**Subject:** Application ID: 2006-0230

**TO:** Jean Fraser  
**FROM:** Dan Goyette, PE and Lauren Swett, EIT  
**DATE:** April 24, 2008  
**RE:** 72 Walnut Street Residence

Woodard & Curran has reviewed the Minor Site Plan submissions for the Shopov Residence at 72 Walnut Street. The construction of a residential building is proposed for the site along with associated site improvements and utility connections.

Date: 04.21.09  
Scale: 1" = 10'  
Drawn: MLC  
Project: SHOPOV 05-093  
Sheet: SITE & UTILITY PLAN  
GRADING & DRAINAGE PLAN  
SP-1

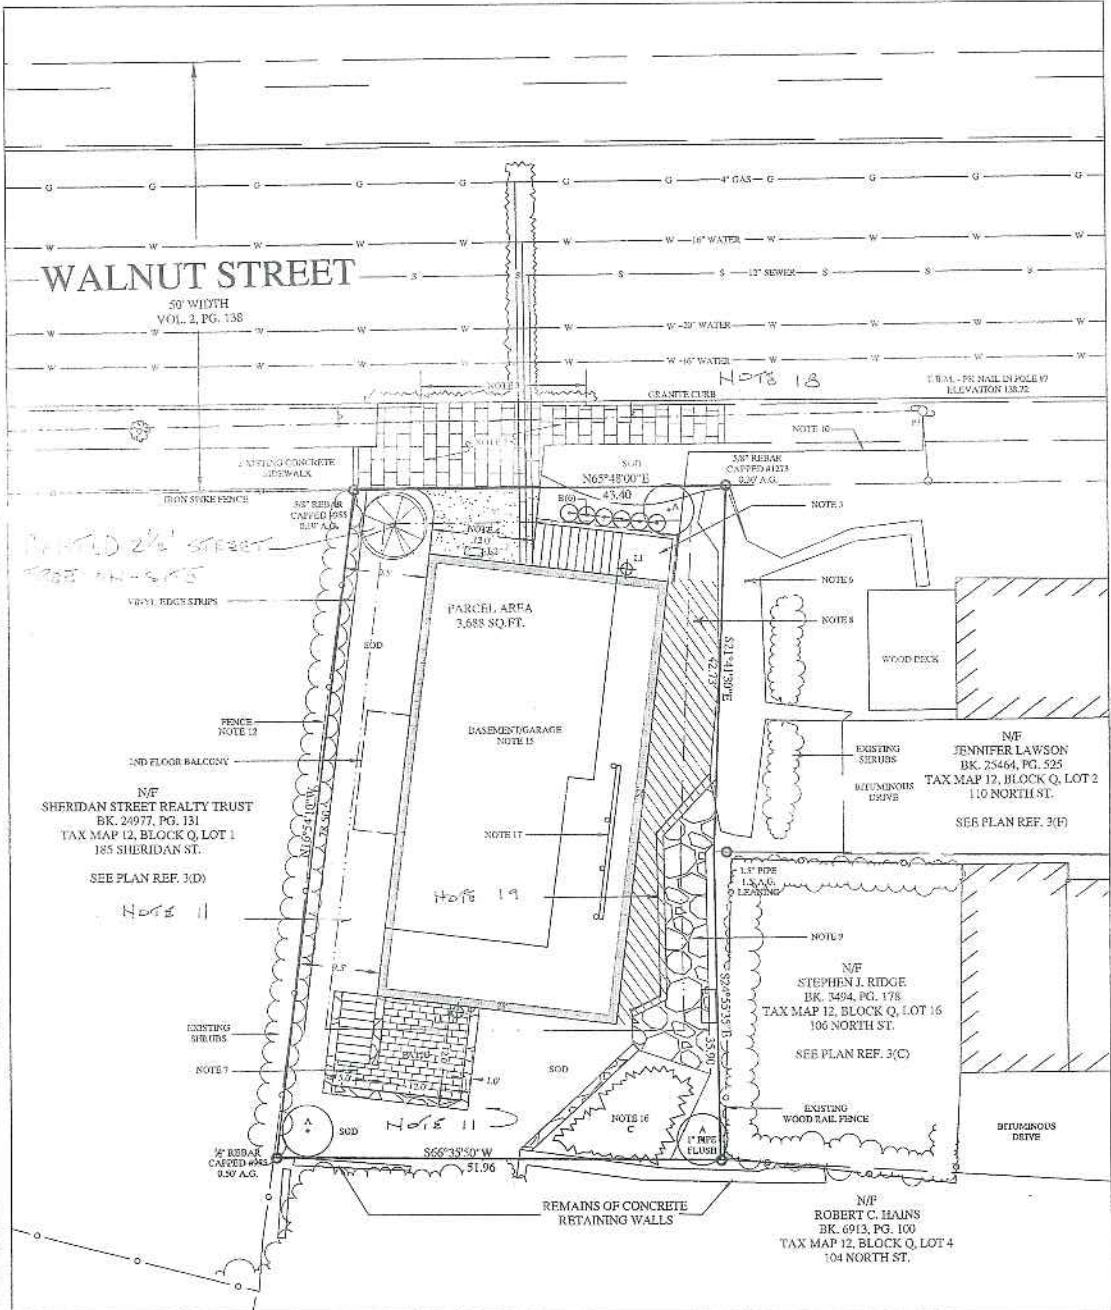
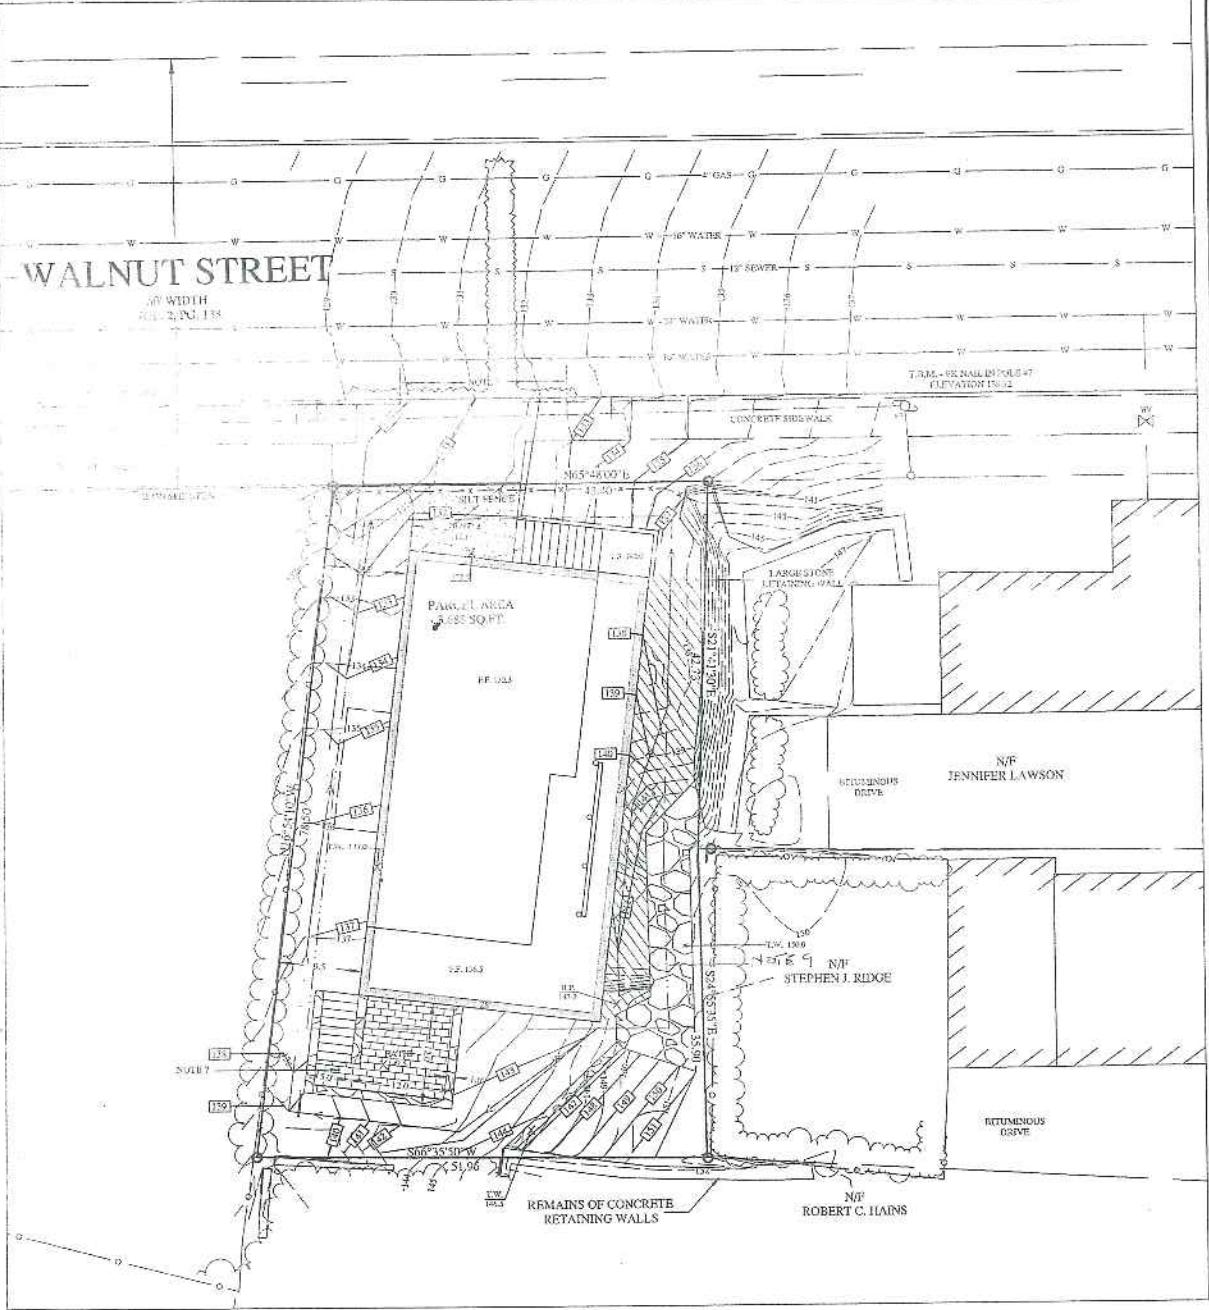
- It is not clear how the gutters of the building will all discharge to the detention pond. Downspouts are shown at locations outside of the pond.
- Grading arrows are shown on the plans. Spot grades should also be included to insure that the surface drainage is directed to the appropriate places.

- No soils information has been shown for the pond. Will the stormwater infiltrate or will there be standing water? Also if the plan is for the stormwater to infiltrate then no foundation drains will be allowed in the area of the pond. If foundation drains are present the pond will just enter the foundation drain and glow into the City system there by defeating the purpose of the pond.

- The pond bottom is shown as crushed stone. A vegetated bottom is preferred.
- The large retaining wall is shown to end on a neighbor's property (southern property boundary). Documentation showing rights to do this should be provided.

- A catch basin is called out on the plans but no detail has been provided.

Date 4.20.09  
Scale 1/4" = 1'-0"  
Drawn  
Job  
Sheet  
Of 11 Sheets

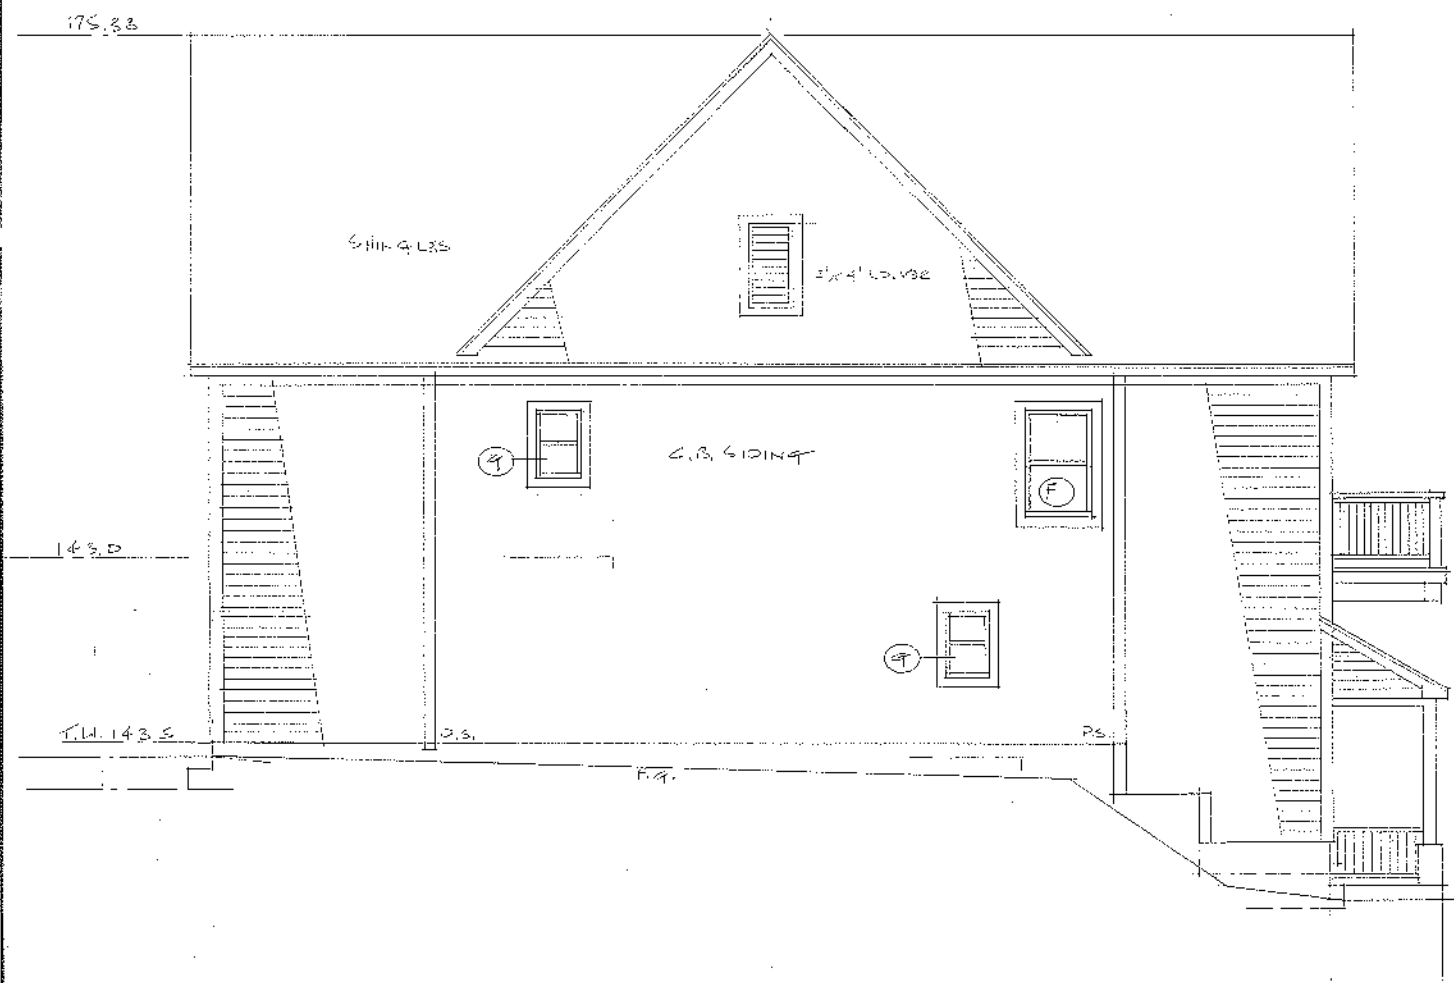
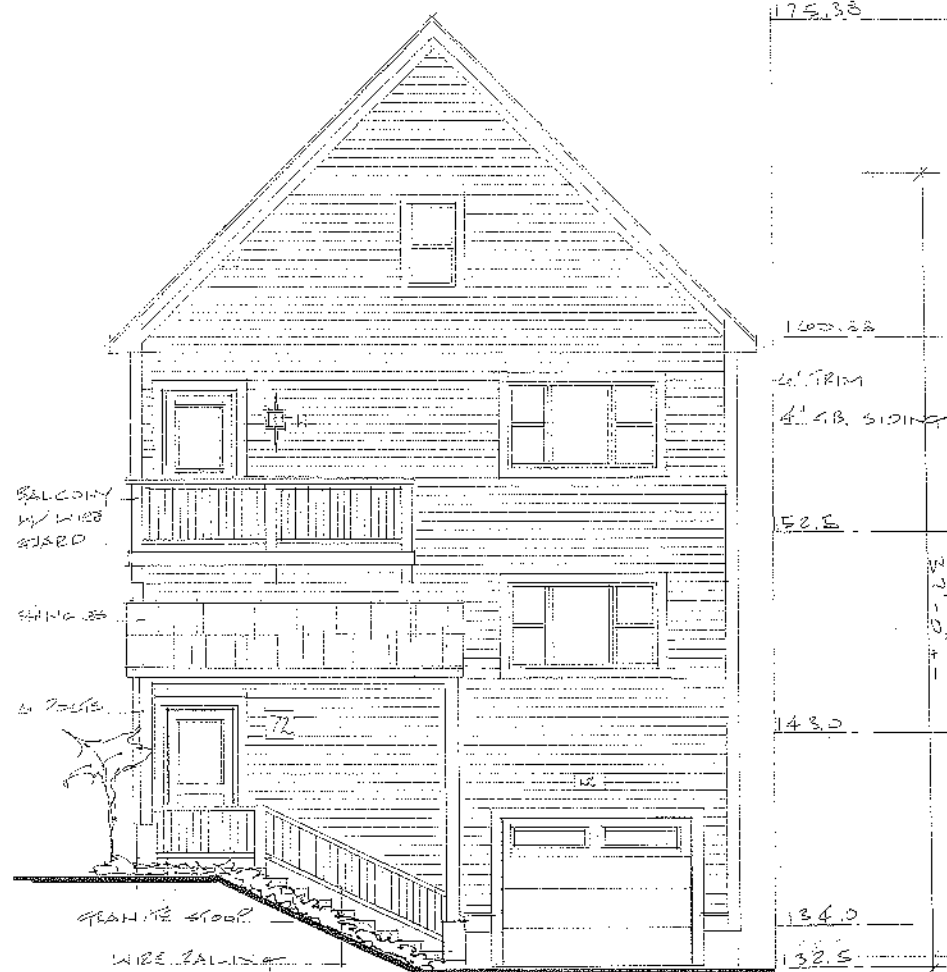
Although the actual height of the structure appears to be meeting the maximum height requirements, I am still questioning the dimensional accuracy of plan A-1. The grade elevation is given as 132.5' and the ridge height is given as 179.0'. Mathematically that translates to 46.5' between the two. However, when a 1/4" scale is put on the plans, it scales closer to 41.5'. That is why I am questioning the accuracy of the plans. 5' difference seems like a big discrepancy. I want to be able to rely upon the submitted plans.

I reviewed the plans I received on 12/10/08. The setbacks are now being met based on a patio on the rear instead of a structure. The building elevation plans do not scale correctly compared to the given elevations denoted on the plans. There is a 5 foot difference. I would like verifications on the actual numbers that can be relied upon.

REAR ELEVATION  
1/4" = 1'-0"

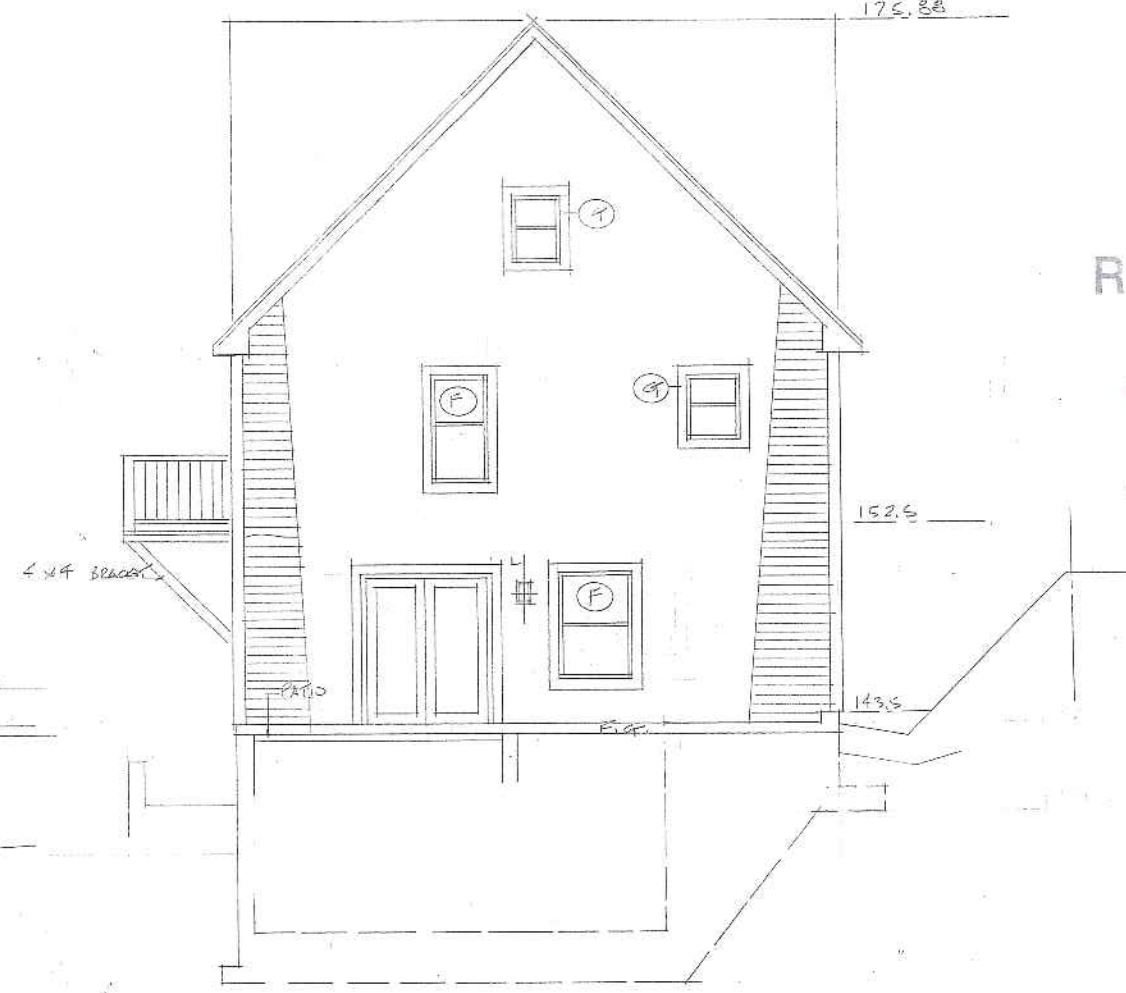
I have reviewed the floor plans which look ok. I am concerned looking at the floor plans and the building elevations plans that there might be some rear steps down to the patio which are not shown. So I would want some sort of verification about that prospect. If there are intended stairs down to the patio, they would be required to be shown on the site plan and other plans.

Detention Pond

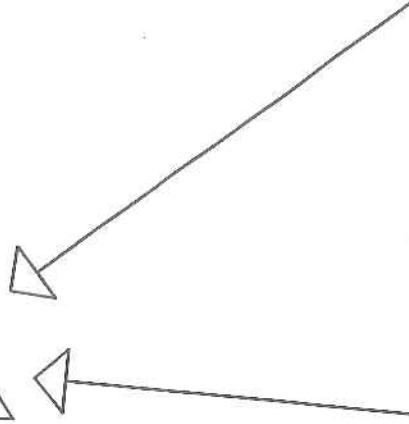
The reviewer is confused why the applicant has provided storage on-site. It is not required.
